ESC Review Comments Response

July 5, 2023
City of Albuquerque
Development Review Services
Attention: Chancellor English

Re: **Erosion and Sediment Control Plan for BP-2022-45669
Luxelocker, Luxury Boat & R.V. Storage
5601 San Diego Avenue NE, Albuquerque, NM 87122**

Sheet Number:
C1
1 of 4

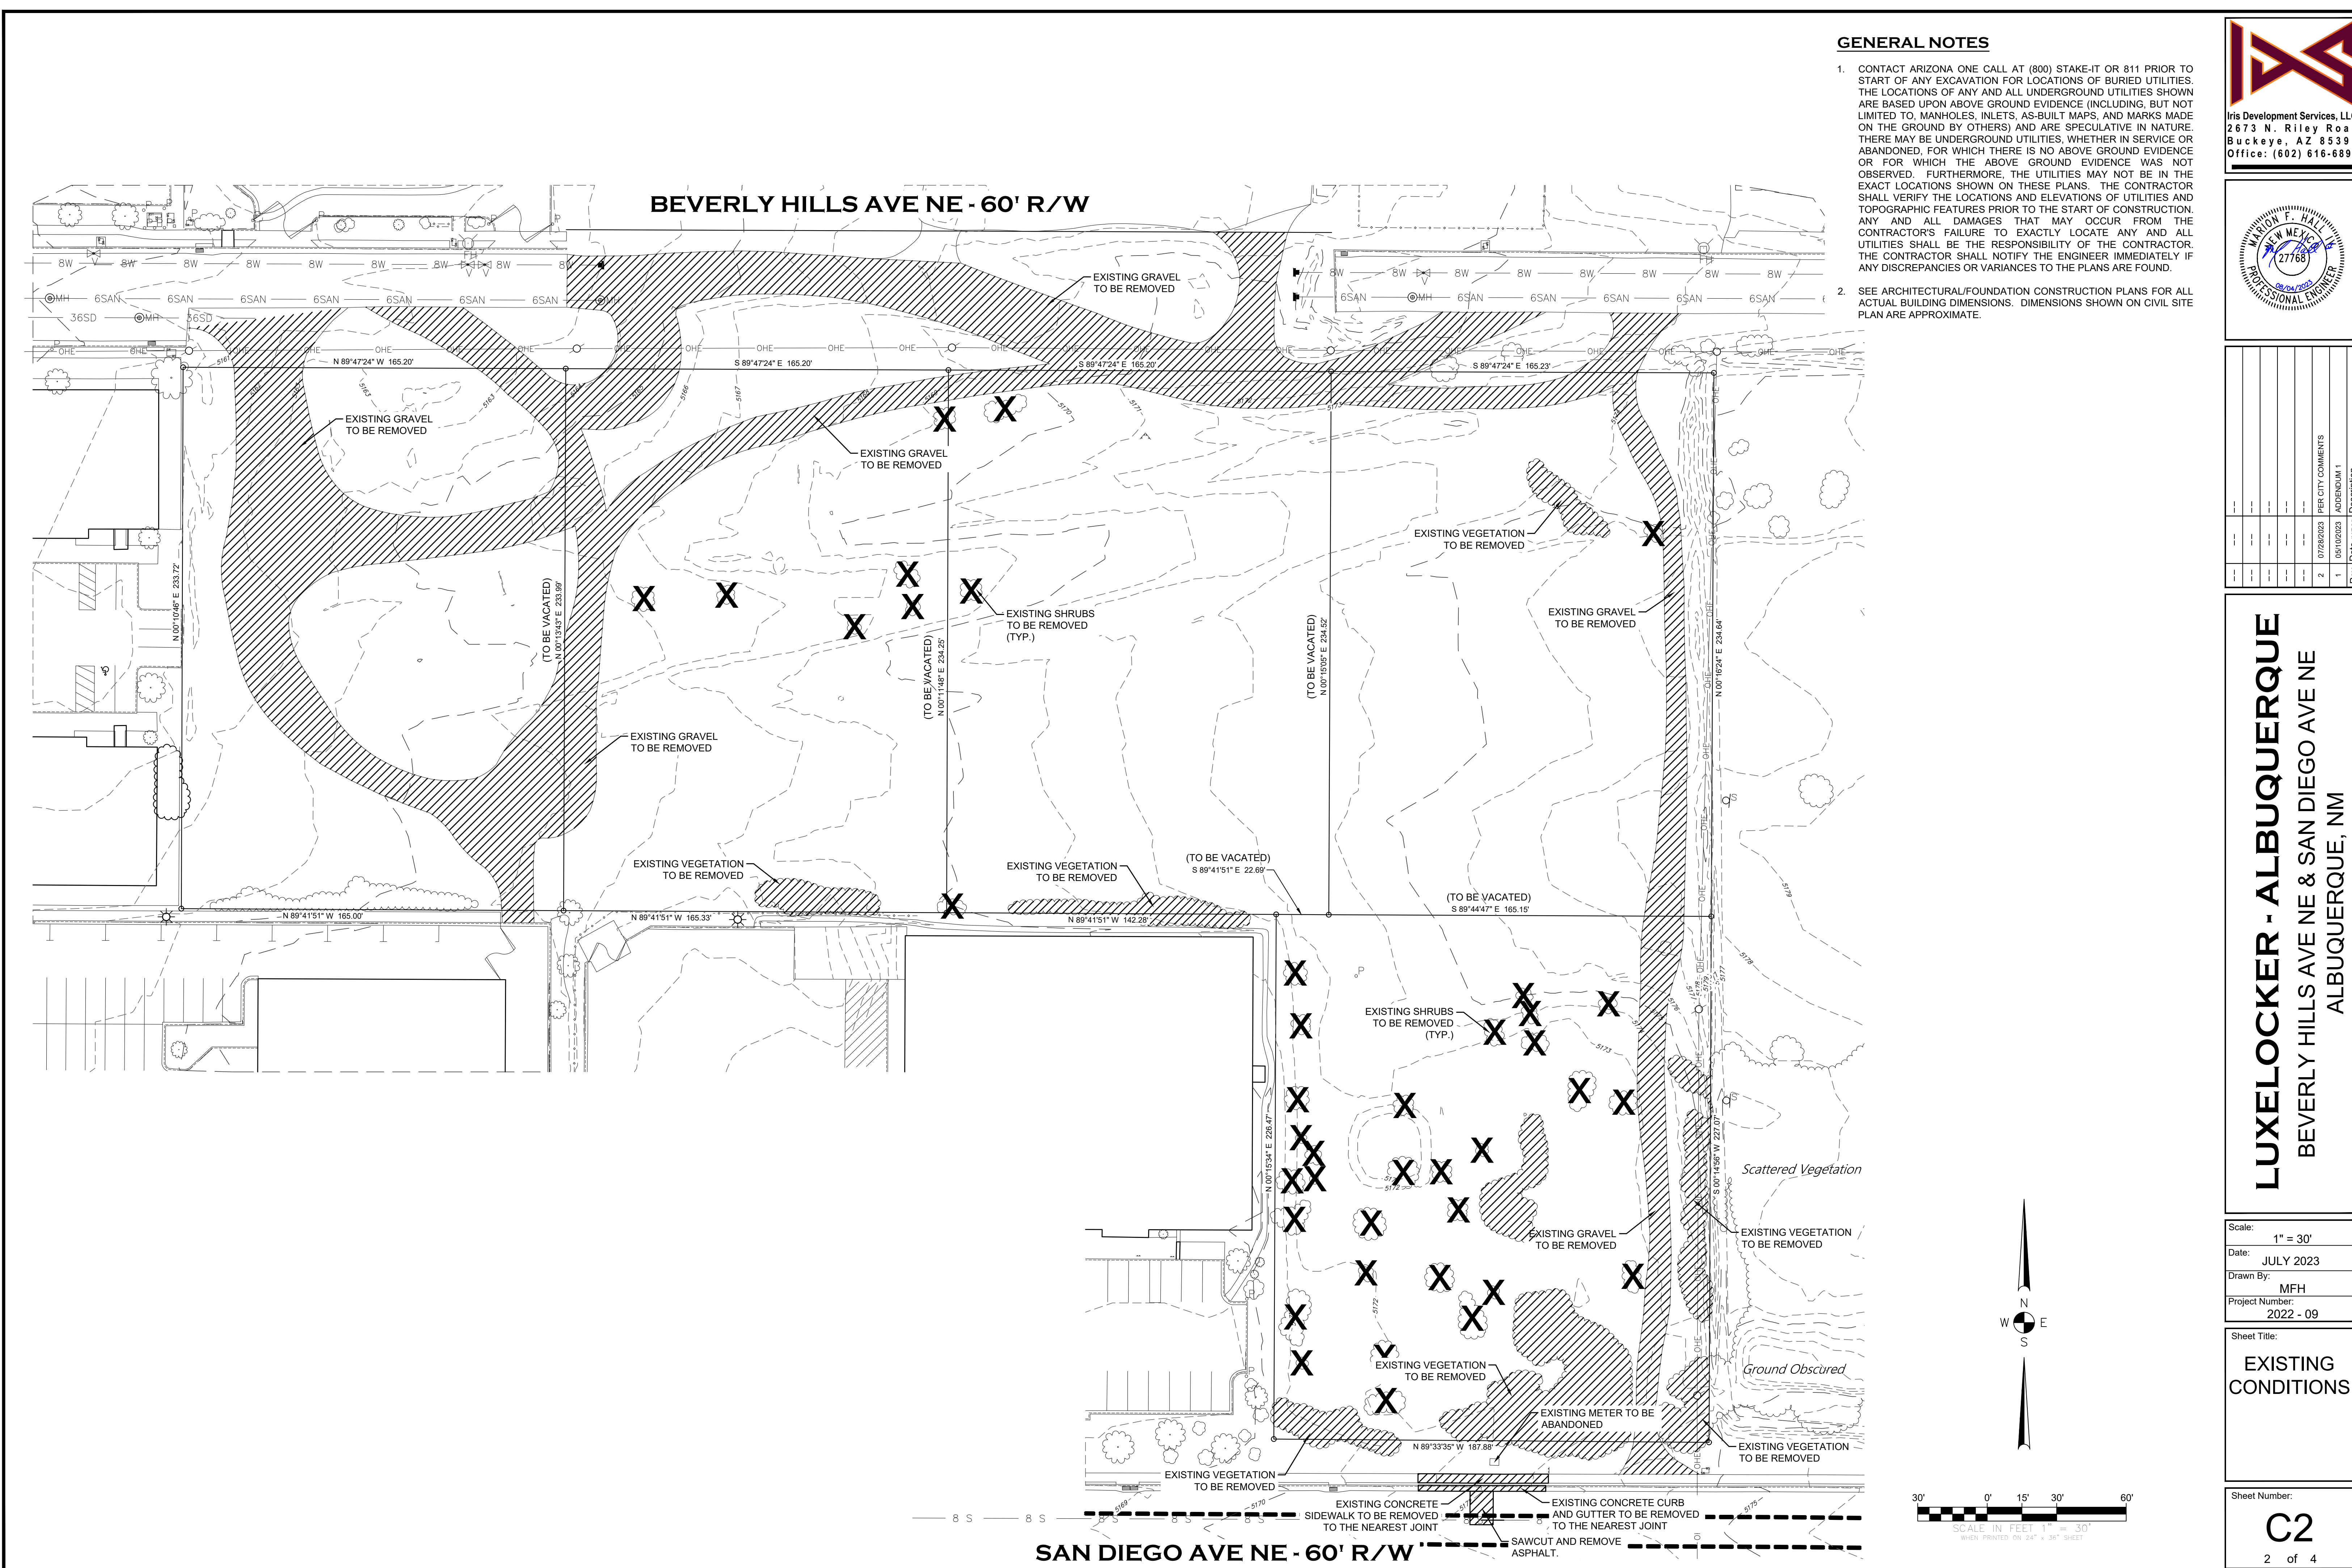
1. The General Notes and Construction Notes should be amended to add the City's ESC Plan Standard Notes, which can be found on the City of Albuquerque's website: www.cabq.gov/planning/development-review-services/stormwater-quality-section.
R1. The City's Erosion Control Notes have been provided on sheet C1.

2. Vicinity map – add a zone atlas map clearly indicating location and street names.
R2. A vicinity map with street names has been provided on Sheet C1.

1
C4
SILT FENCE DETAIL
SCALE: NONE

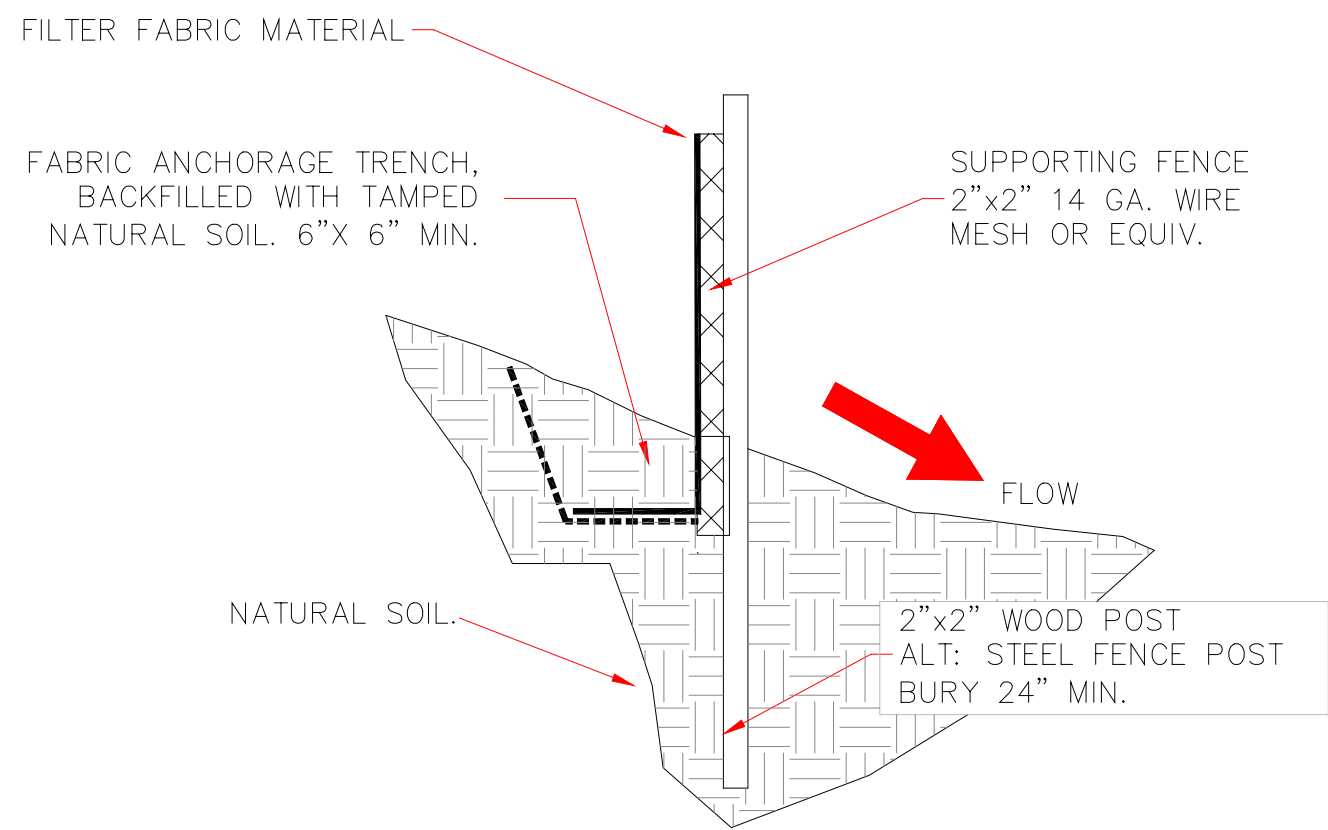
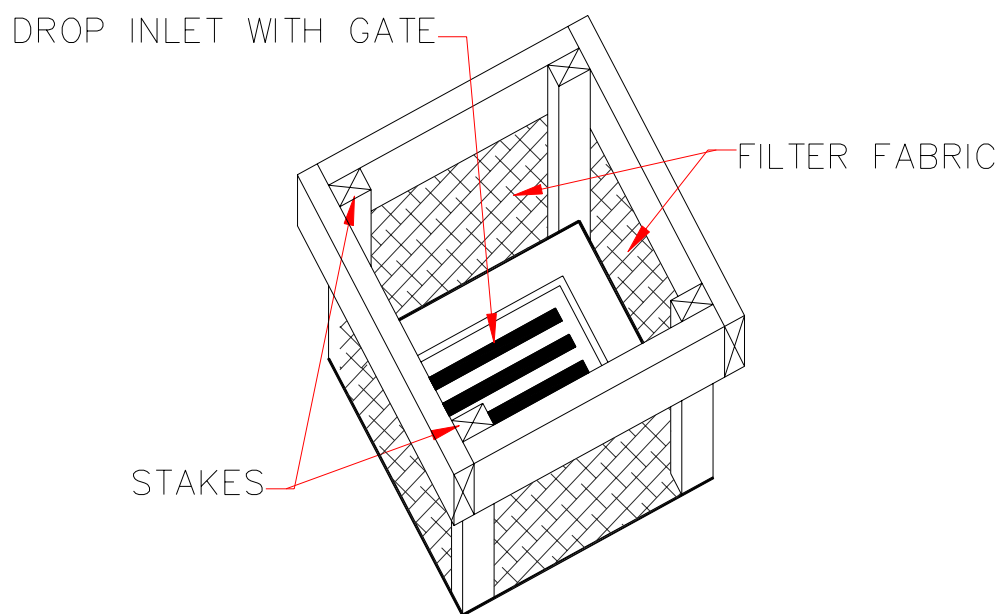
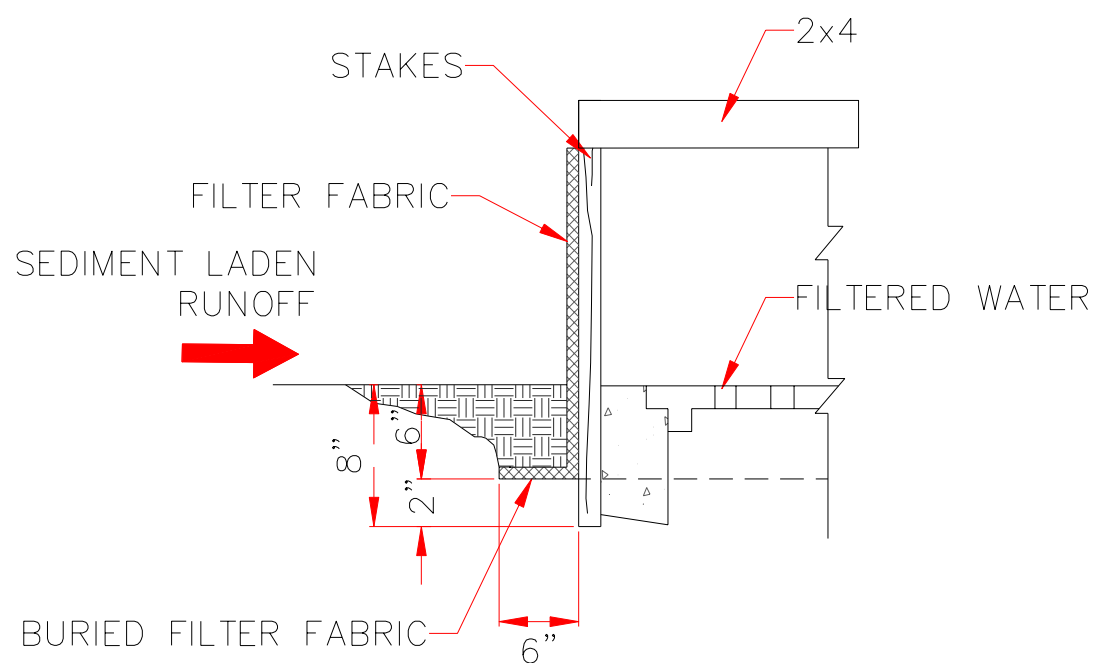
3. The perimeter controls listed in the SWPPP and on the ESC Plan do not match. Amend the ESC Plan map to installation of silt fencing around the perimeter, as straw wattles are not sufficient for perimeter control.
R3. The perimeter controls have been revised from straw wattles to silt fence to match what is listed in the SWPPP document. This is shown on Sheet C3.
